## OFFICIAL NOTIFICATION OF DECISION

**Project# PR-2018-002496**  
**Application#**  
**SI-2019-00180 SITE PLAN – DRB**  
**SD-2019-00161 PRELIMINARY/FINAL PLAT**

All or a portion of LOTS 1--4 BLOCK 4 TRACT 3 UNIT 3 NORTH ALBUQUERQUE ACRES, zoned MX-L, located at the SEC of BARSTOW ST NE AND ALAMEDA BLVD NE, containing approximately 3.38 acre(s). (C-19 & 20)

1 Site Plan - West
1" = 20'-0"

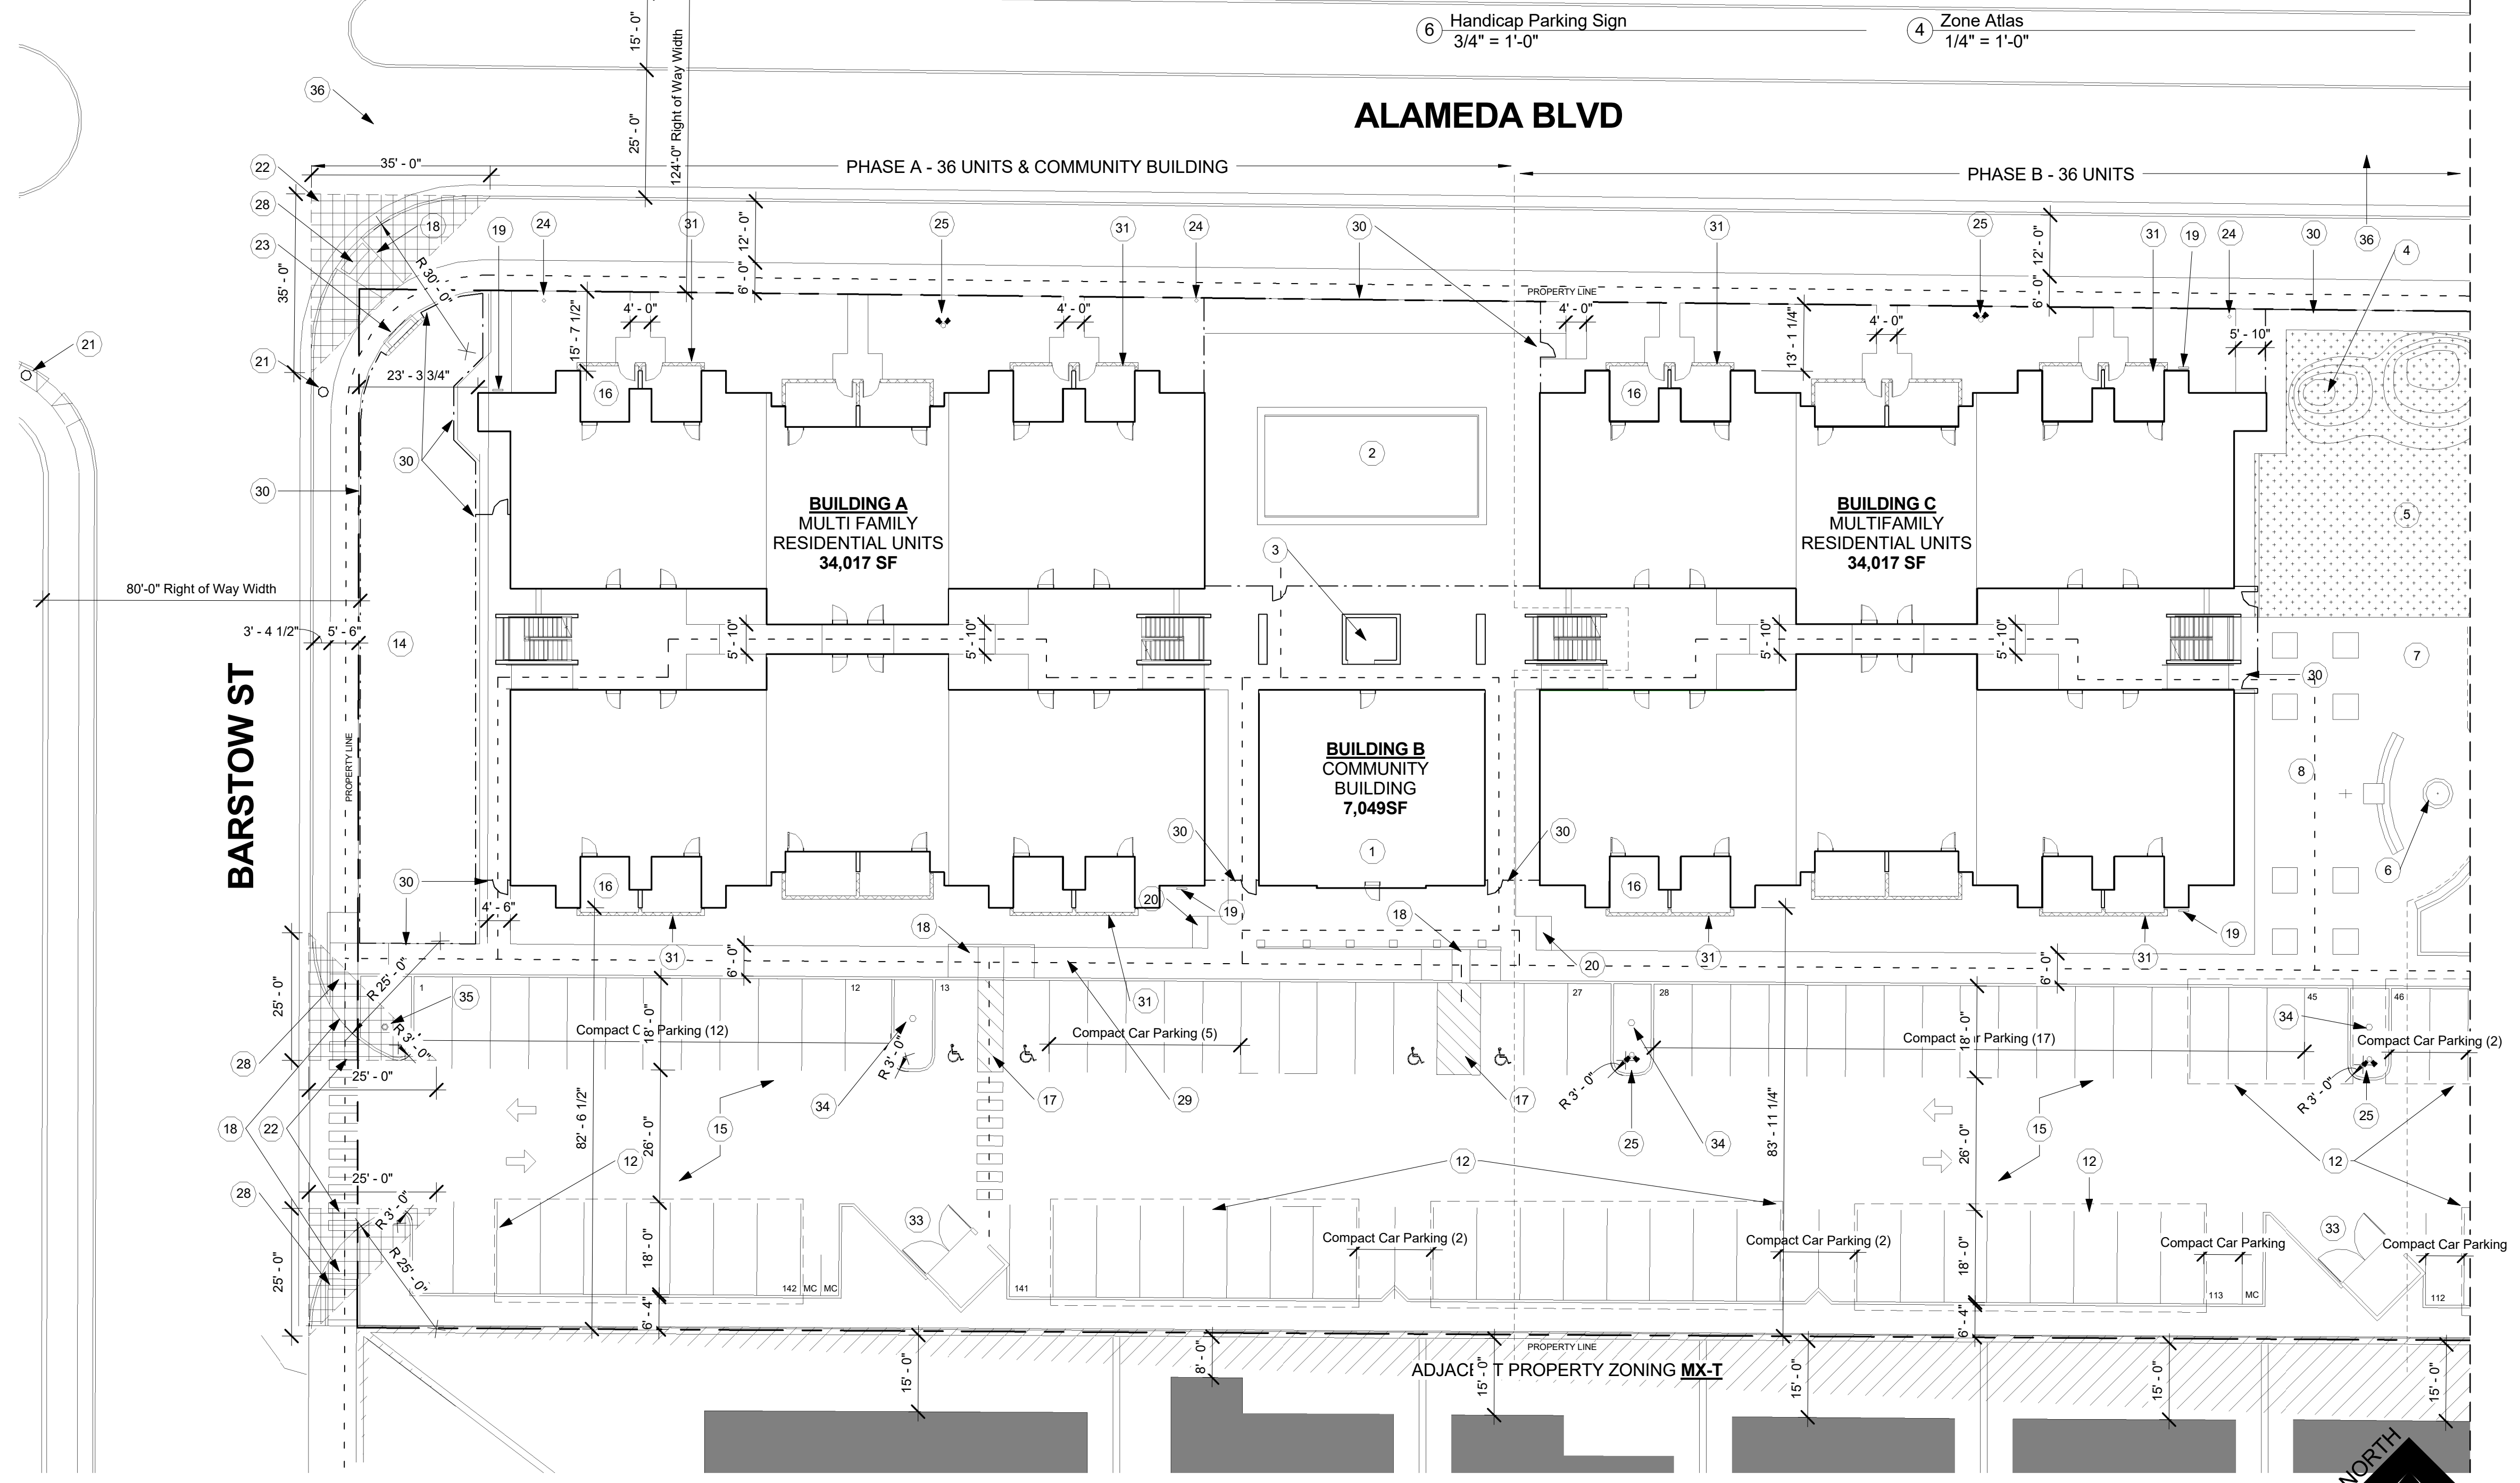
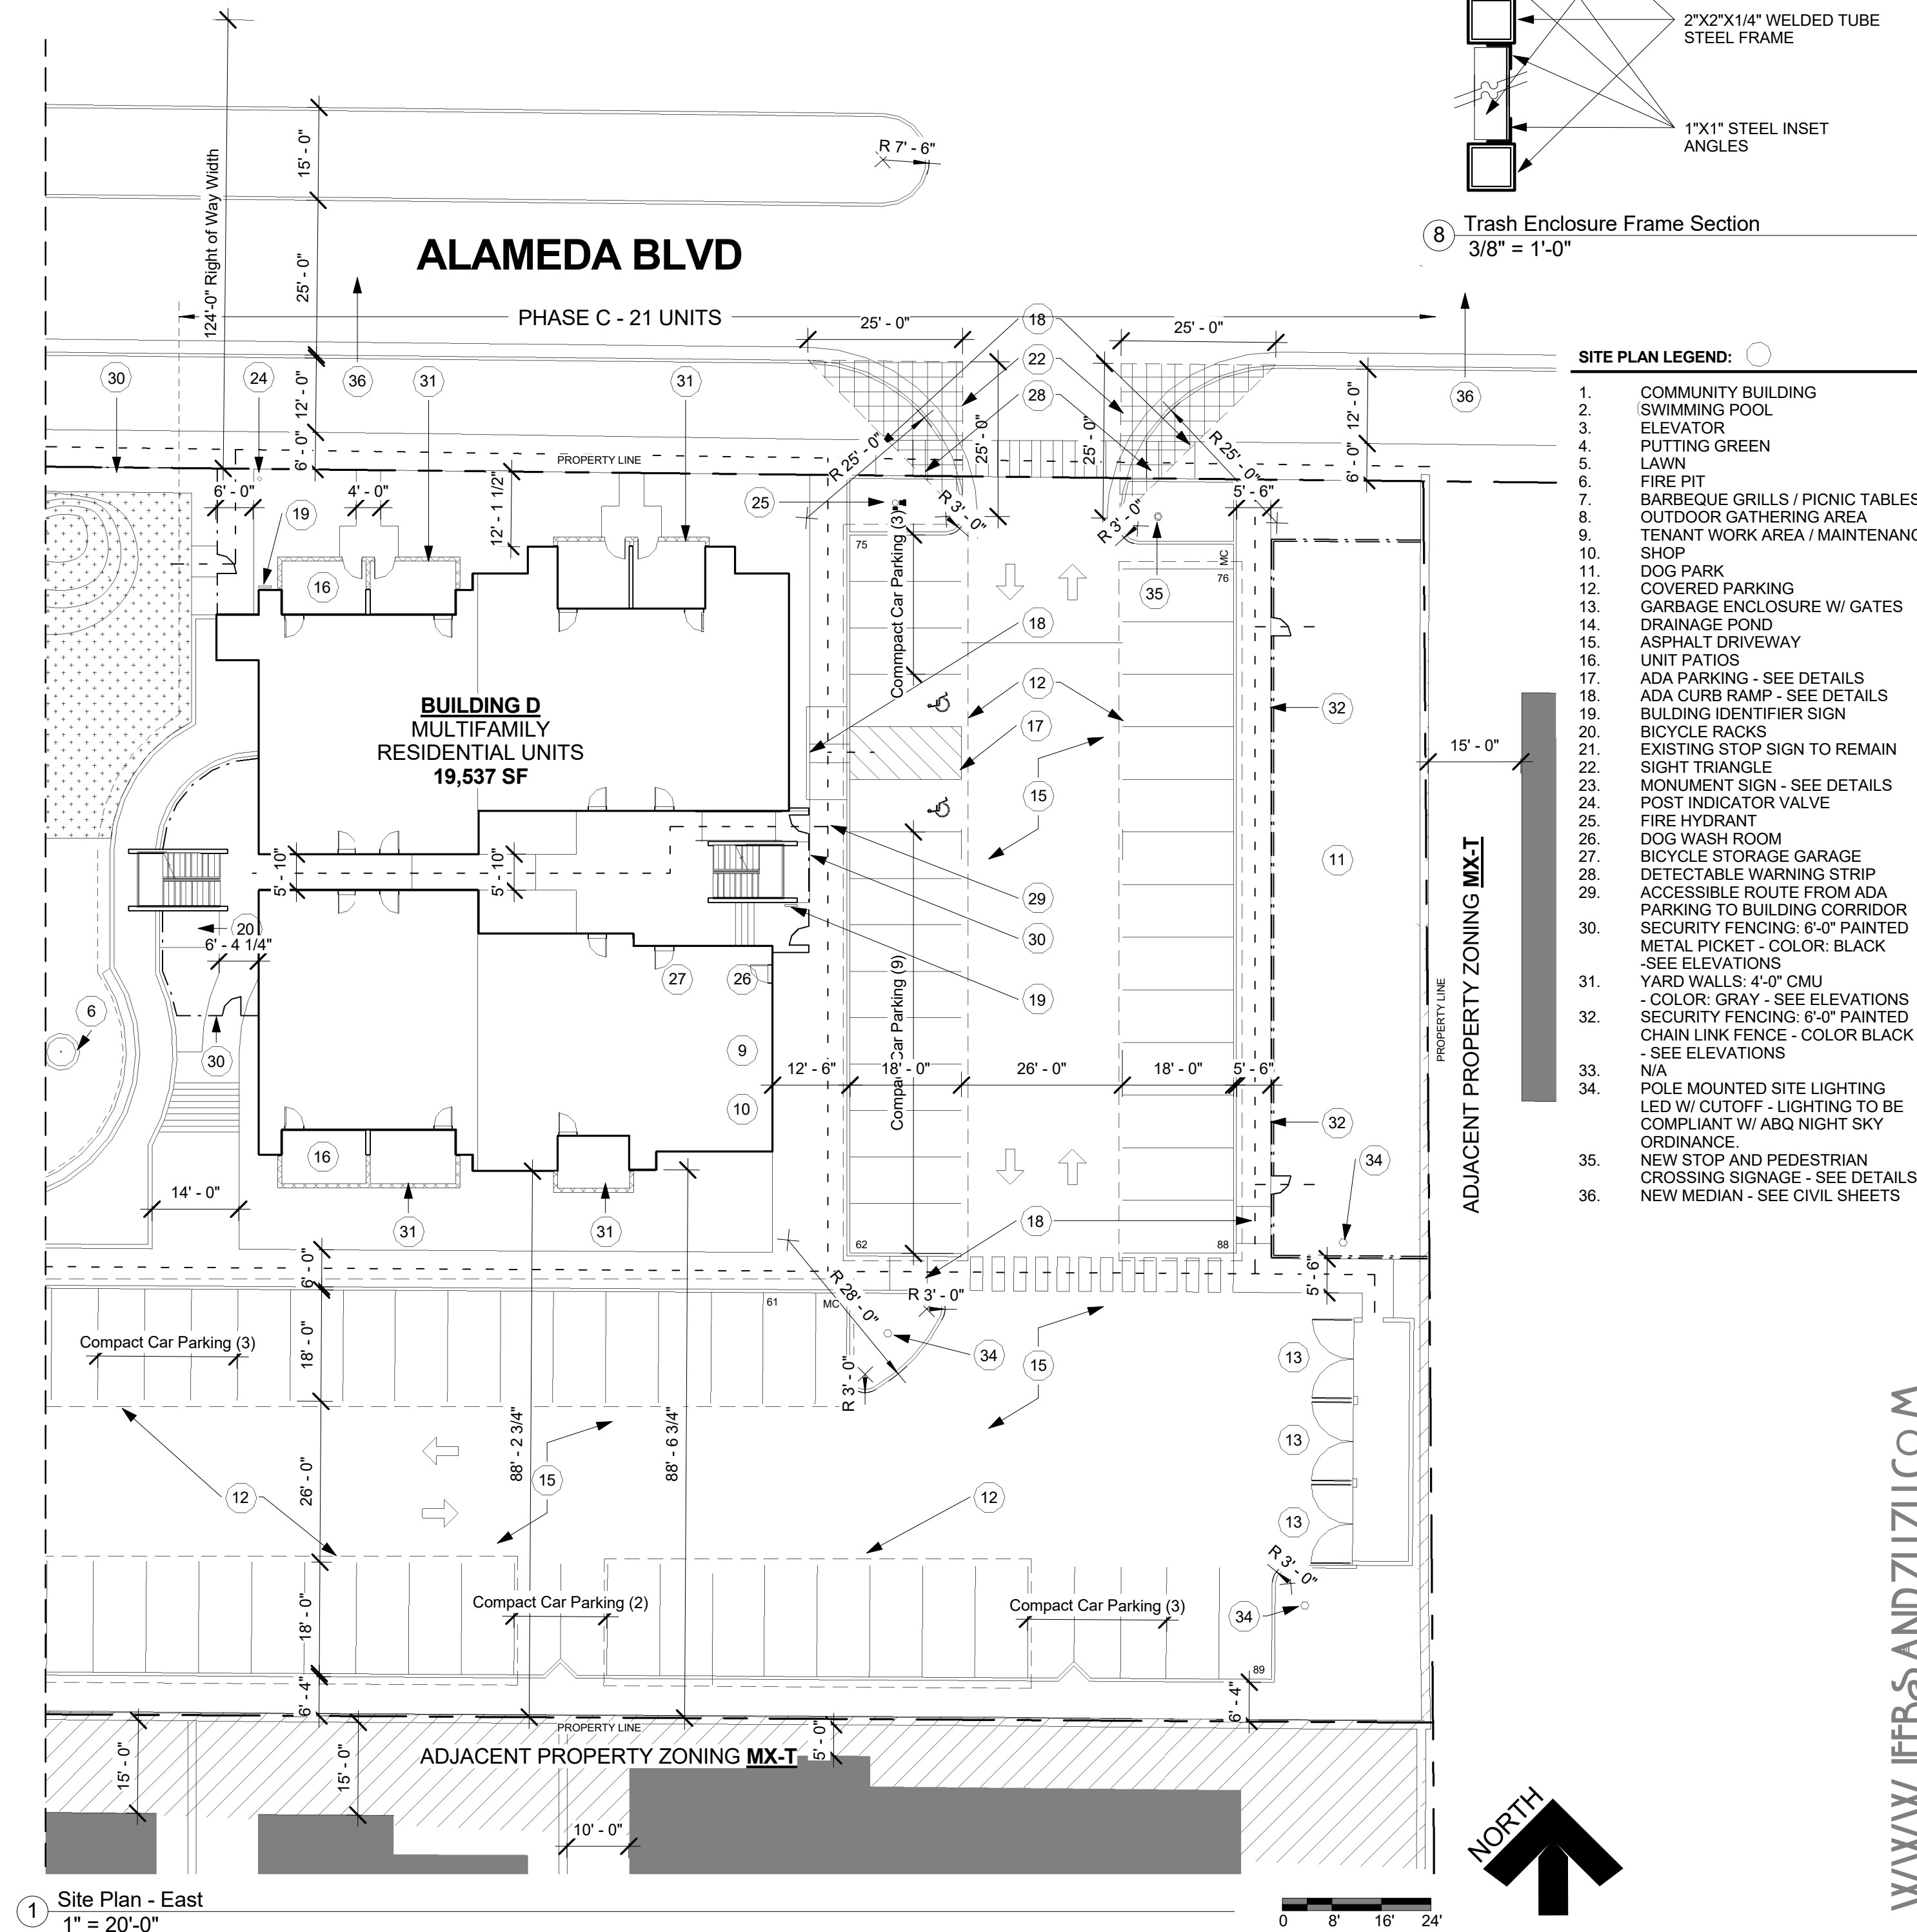
8. The carports along the southern boundary are structures and must be set back 15 feet from the rear property line. These structures must be relocated to meet this requirement as described by Code Enforcement.

1. This Site Plan is valid 5 years from DRB approval (9-26-2019). An extension may be requested prior to the expiration date.
2. Final sign off is delegated to Planning to check for an executed IIA and Code Enforcement for carport placement.
3. Once the site plan has all the required signatures, a pdf of the complete signed off set will then be email to the PLNDRS.
